City of Portland, Maine - Building or Use Permit Application
 389 Congress Street, 04101 Tel: (207) 874-8703, Fax: (207) 874-8716

Permit No: 04-0861	Issue Date:	CBL: 236 A003001
------------------------------	--------------------	----------------------------

Past Use: Dumpster pad w/tarp cover	Proposed Use: Dumpster pad w/shed roof	Permit Fee: \$255.00	Cost of Work: \$25,090.00	CEO District: 3
Proposed Project Description: Build 27x26 dumpster shed roof		FIRE DEPT: <input type="checkbox"/> Approved <input type="checkbox"/> Denied	INSPECTION: Use Group: Type	
		Signature:	Signature:	
PEDESTRIAN ACTIVITIES DISTRICT (P.A.D.)				
Action: <input type="checkbox"/> Approved <input type="checkbox"/> Approved w/Condition <input type="checkbox"/> Denied				
Signature: _____ Date: _____

STRUCTURAL PLAN
1/4" = 1'-0"

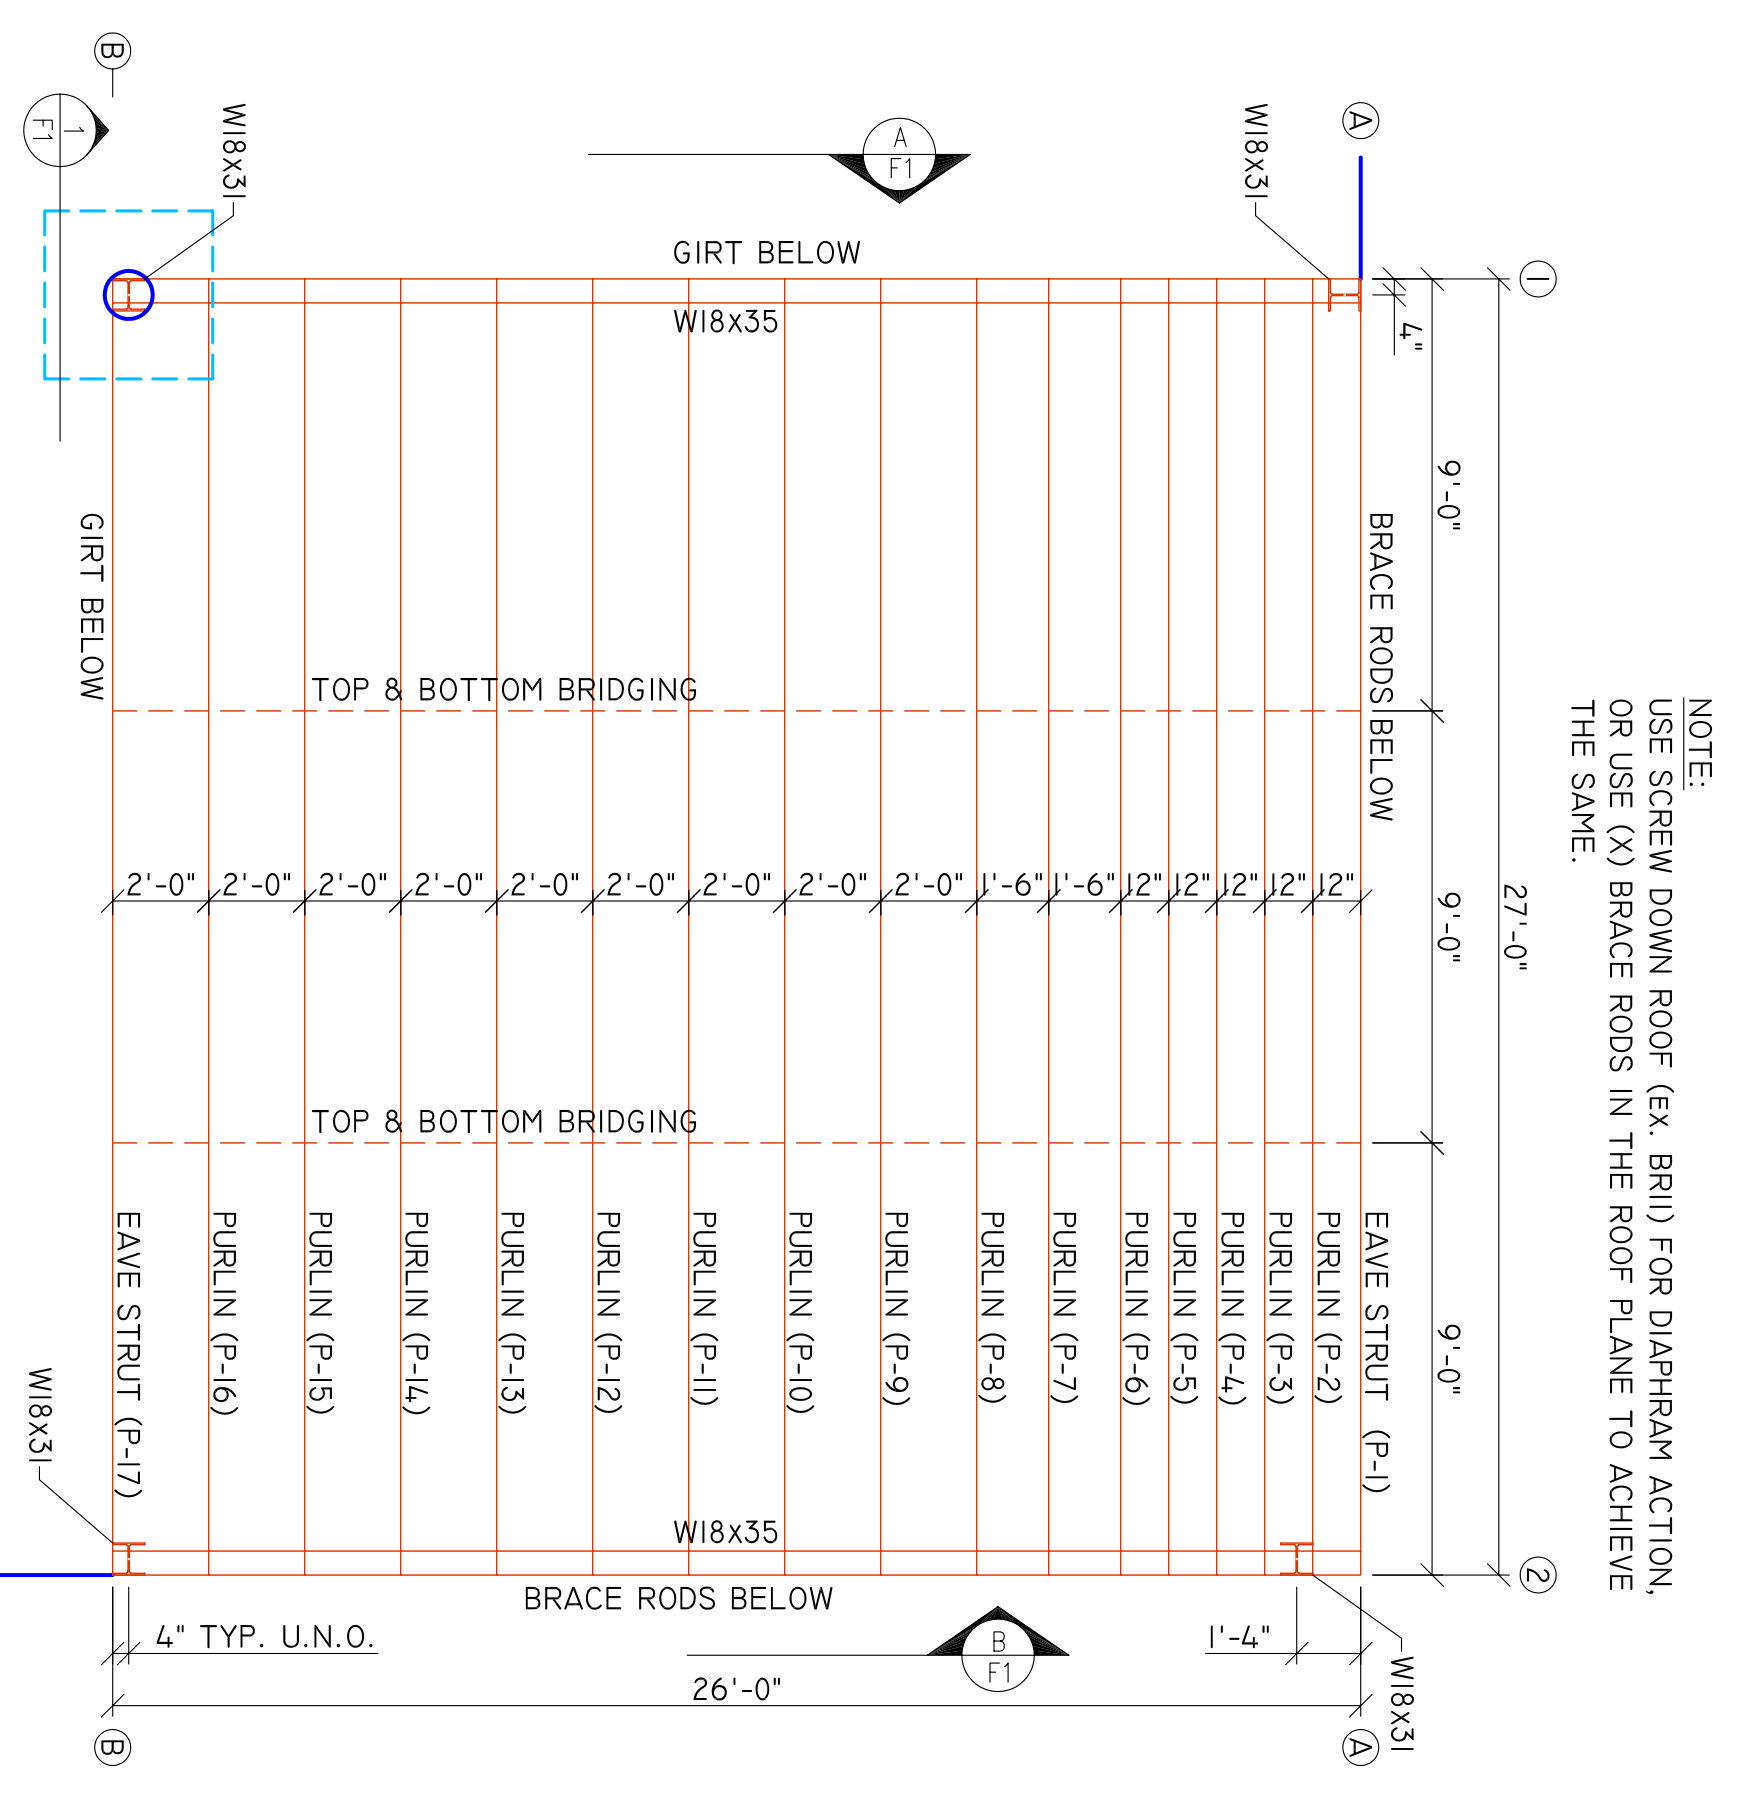
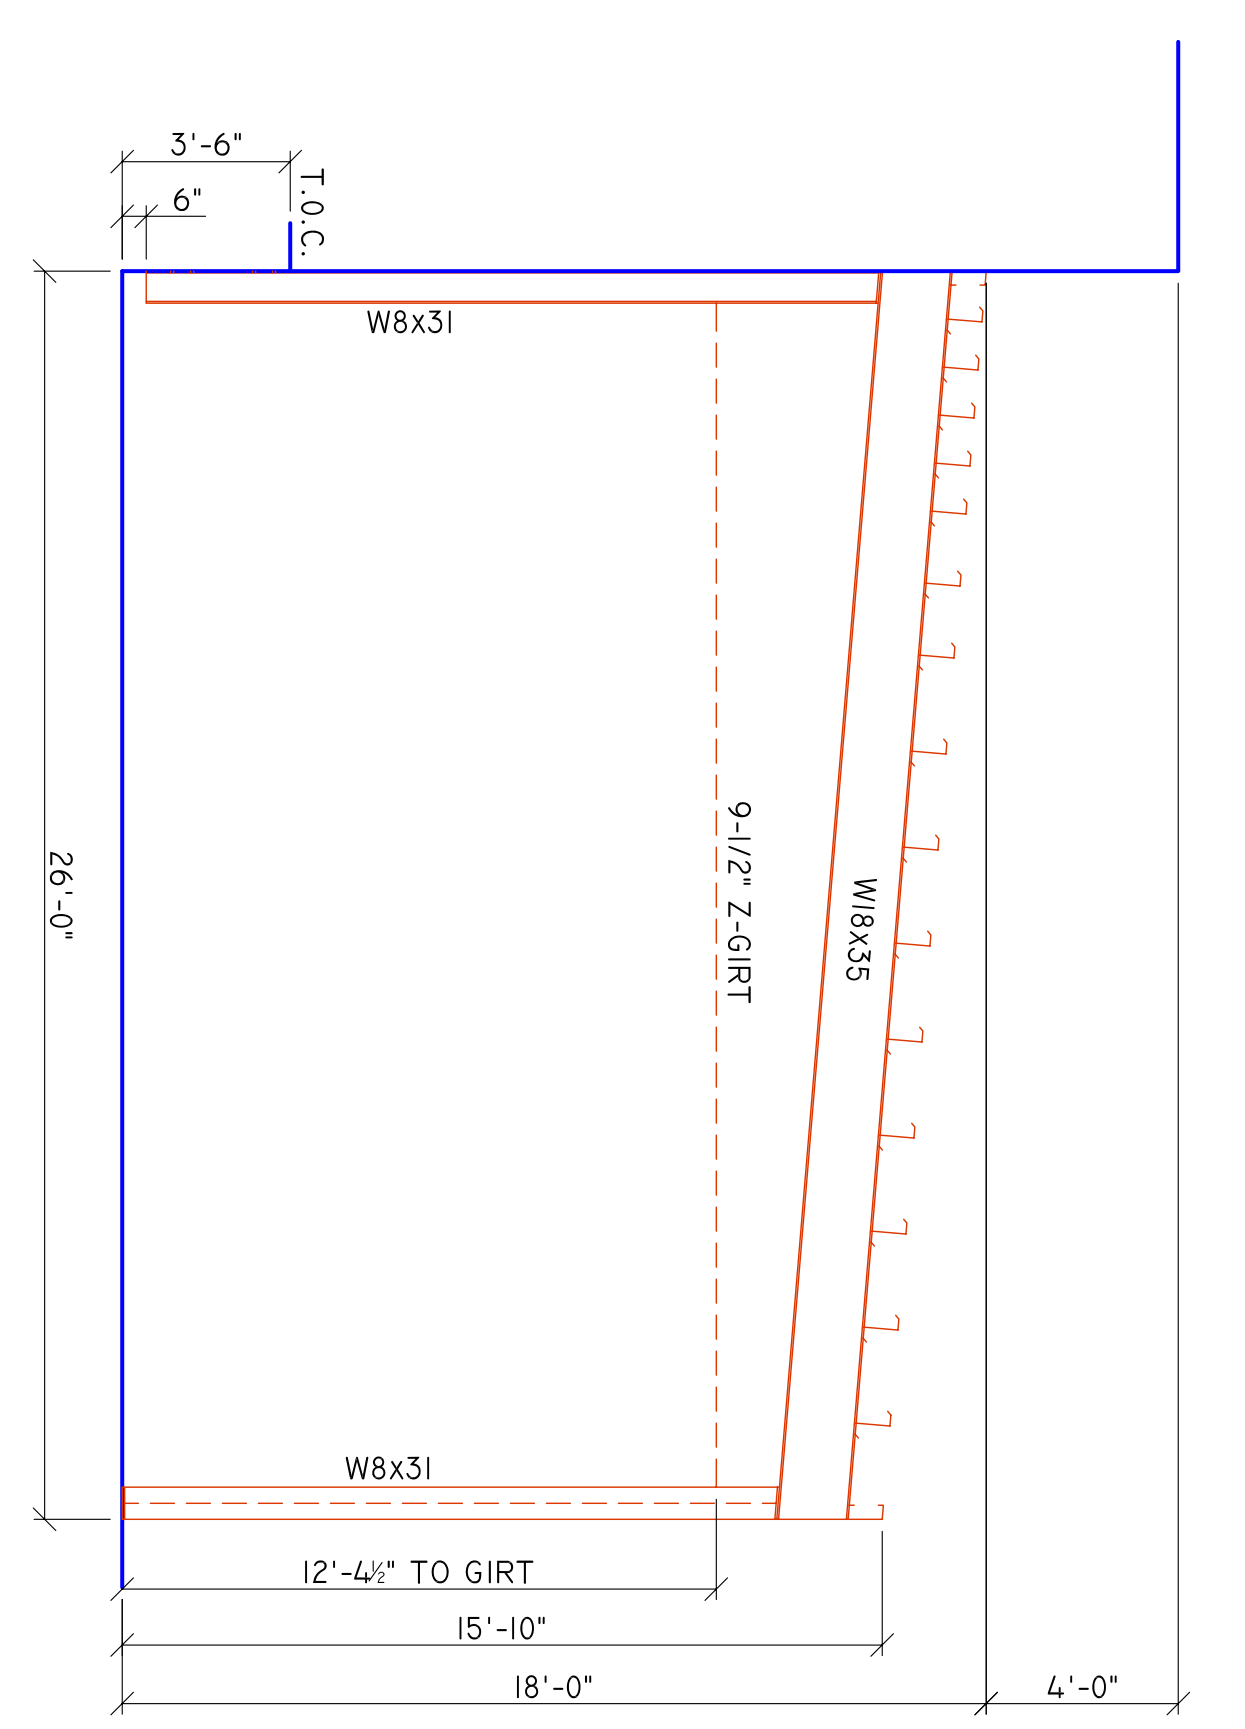
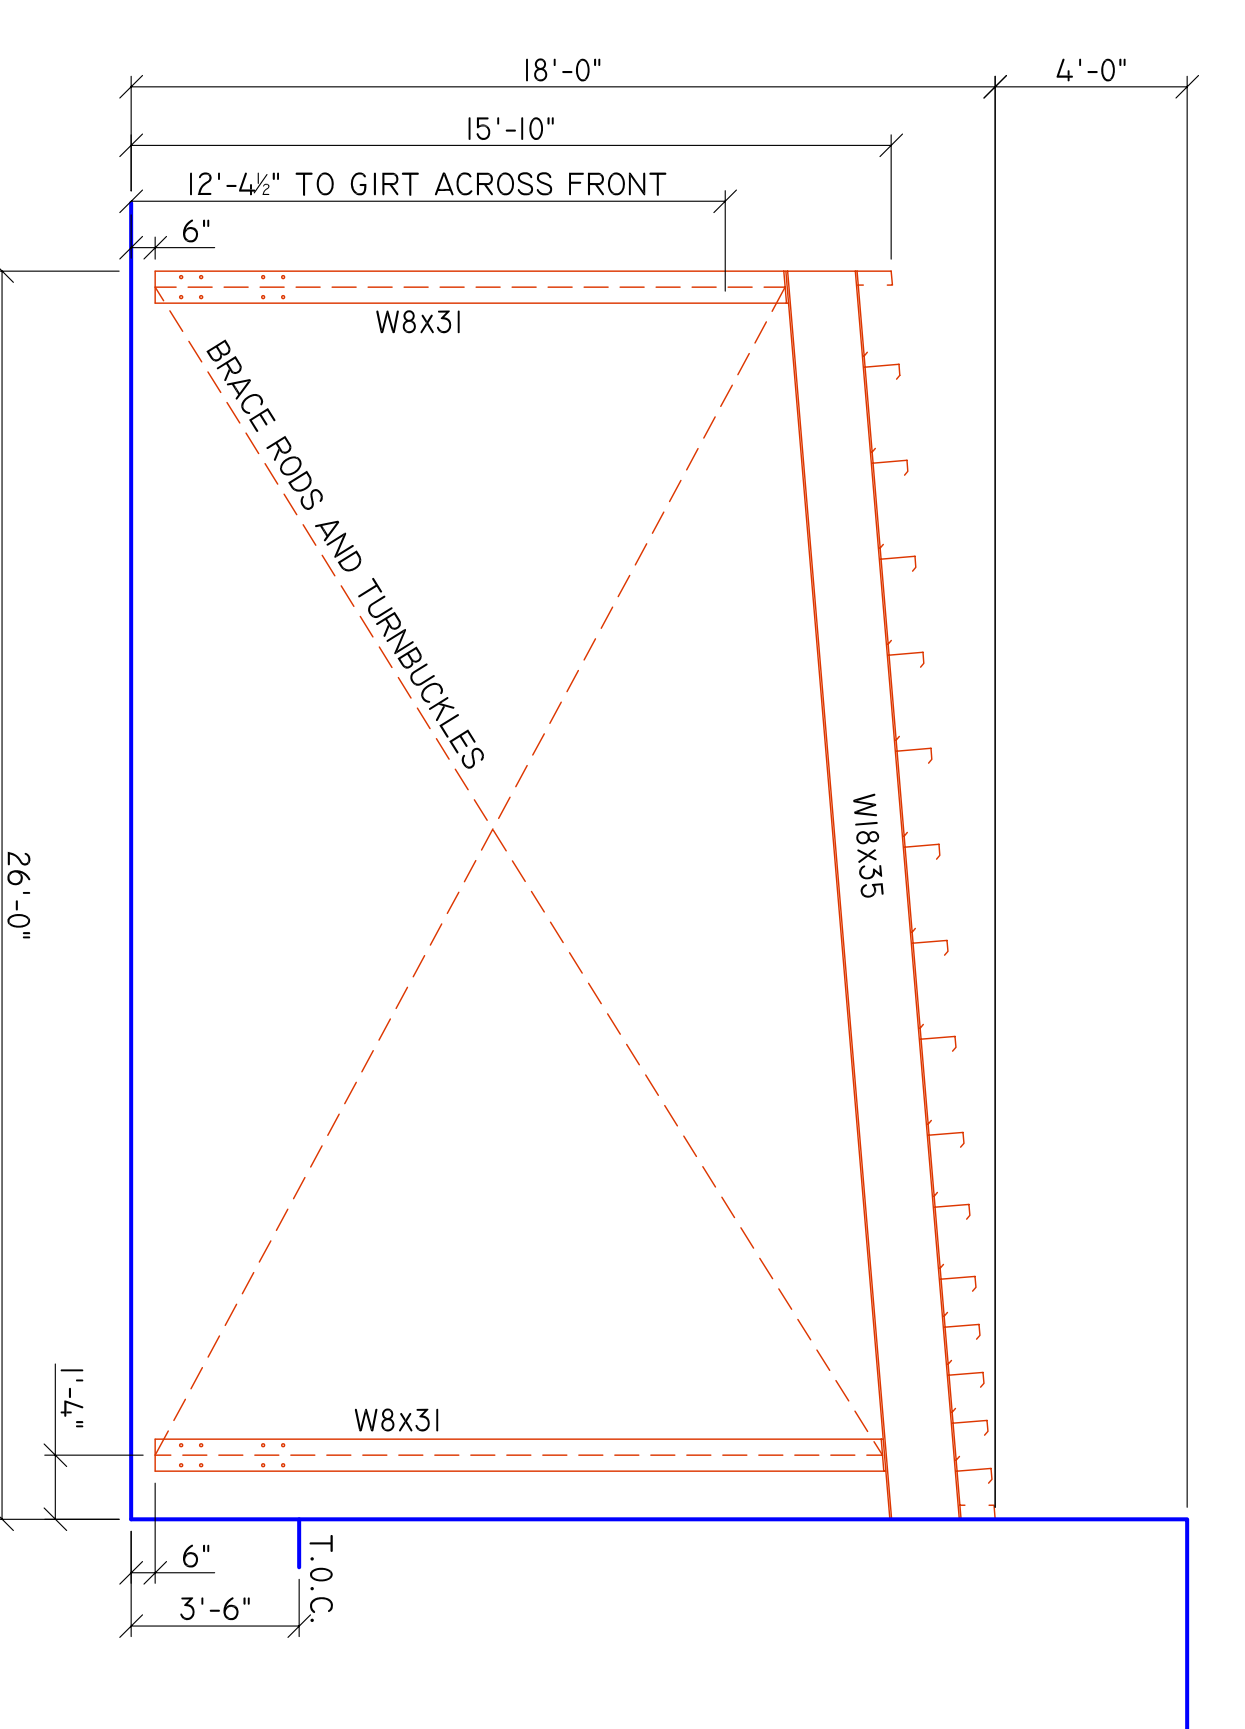
Dept: Zoning	Status: Approved	Reviewer: Marge Schmuckal	Approval Date: 07/01/2004
Note:	Ok to Issue: <input checked="" type="checkbox"/>		
Dept: Building	Status: Approved with Conditions	Reviewer: Mike Nugent	Approval Date: 07/06/2004
Note:	Ok to Issue: <input checked="" type="checkbox"/>		
1) Steel erection subject to Special Inspections see Statement of S/I from Sheridan Corp.			
Dept: Fire	Status: Approved with Conditions	Reviewer: Lt. MacDougal	Approval Date: 07/01/2004
Note:	Ok to Issue: <input checked="" type="checkbox"/>		
1) If the dumpster enclosure is completely enclosed, the sprinkler system shall be extended to the structure.
